CITY OF ALBUQUERQUE

Site: Guardian Storage – La Orilla

Re: Drainage Ordinance (14-5-2-1) Violations for Erosion and Sediment Control and Construction Site Wastes

STABILIZED CONSTRUCTION ENTRANCE
N.T.S.

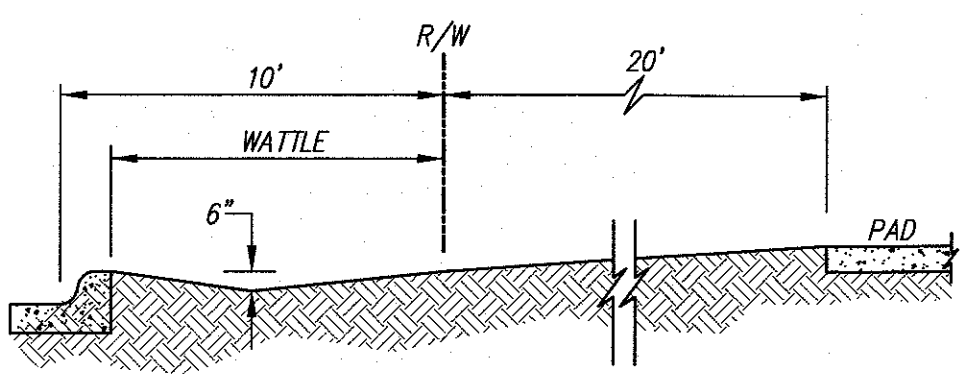
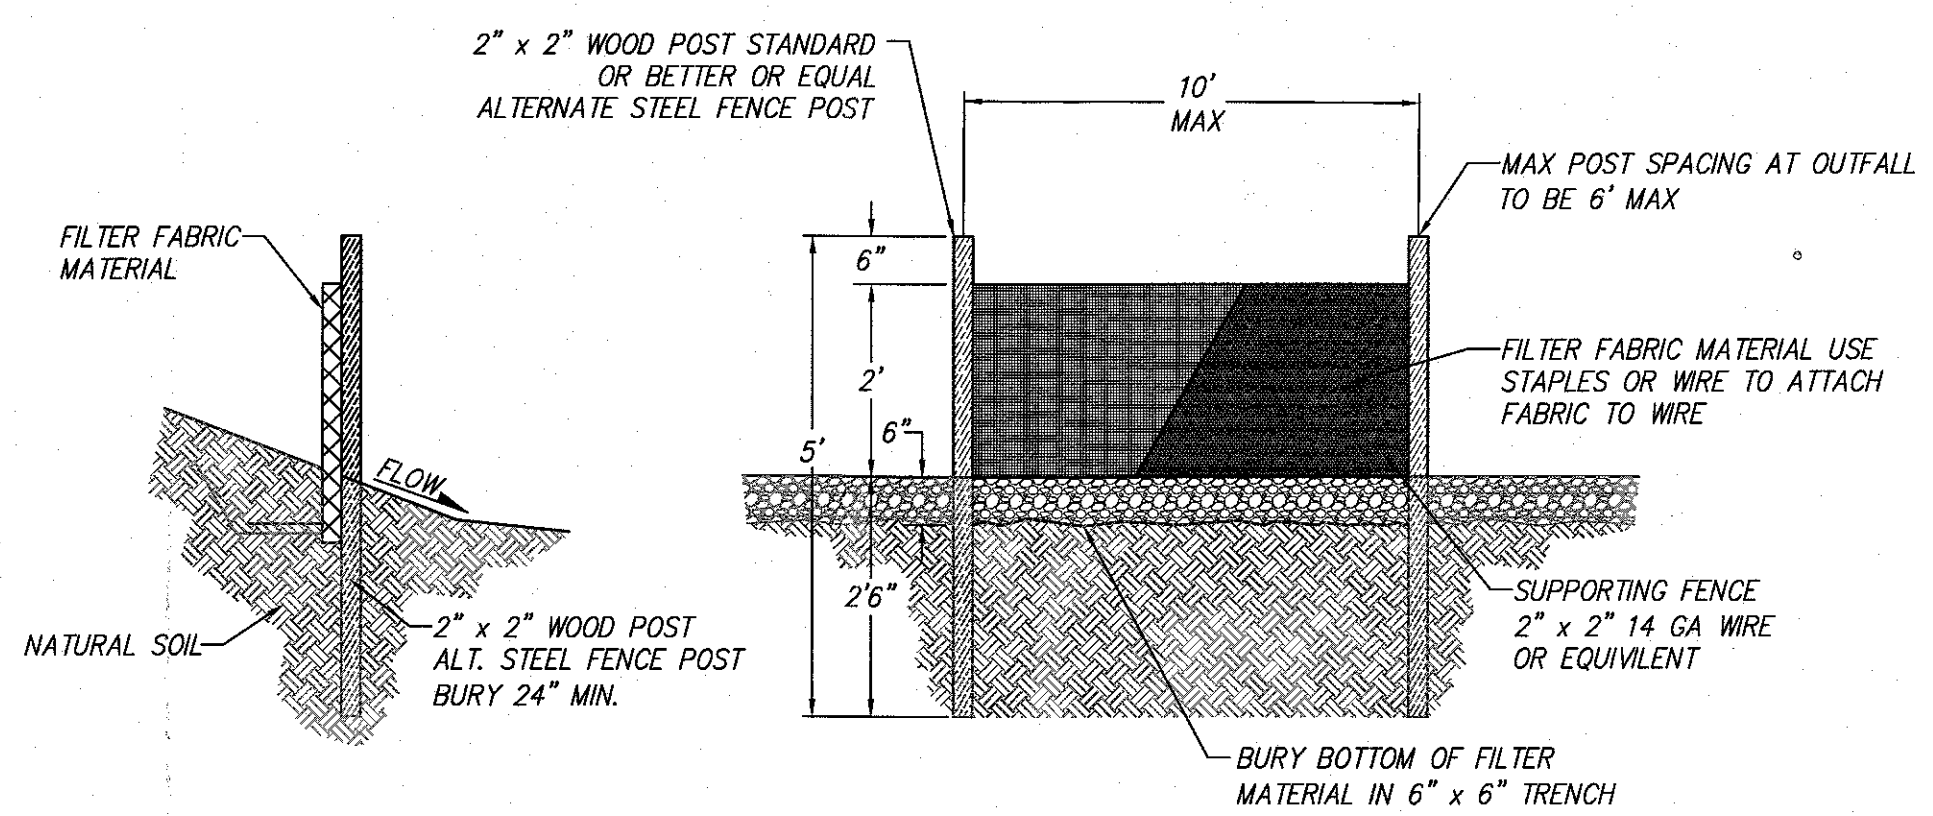
1. No vehicle tracking control.
2. Track-out from site.
3. Sediment in Bosque Plaza Lane and La Orilla Rd.
4. Waste in pond and pond outfall.
5. Wastes throughout the site not in an acceptable container.
6. The waste container was not covered/no ability to cover.
7. Wash-out on the ground/not in an acceptable container.

Track-out onto Bosque Lane.

Track-out onto La Orilla Rd.

1. Provide vehicle tracking control at locations where vehicles exit the site.
2. Remove sediment from Bosque Plaza Lane and La Orilla Rd.
3. Remove waste from pond and pond outfall.
4. Place wastes throughout the site in an acceptable container.
5. Provide a cover for the waste container.
6. Remove wash-out from the ground.
7. Provide an acceptable wash-out facility and have workers use it.
8. Remove sealer material from the ground and prevent sealers/paints/similar materials from contacting the ground.
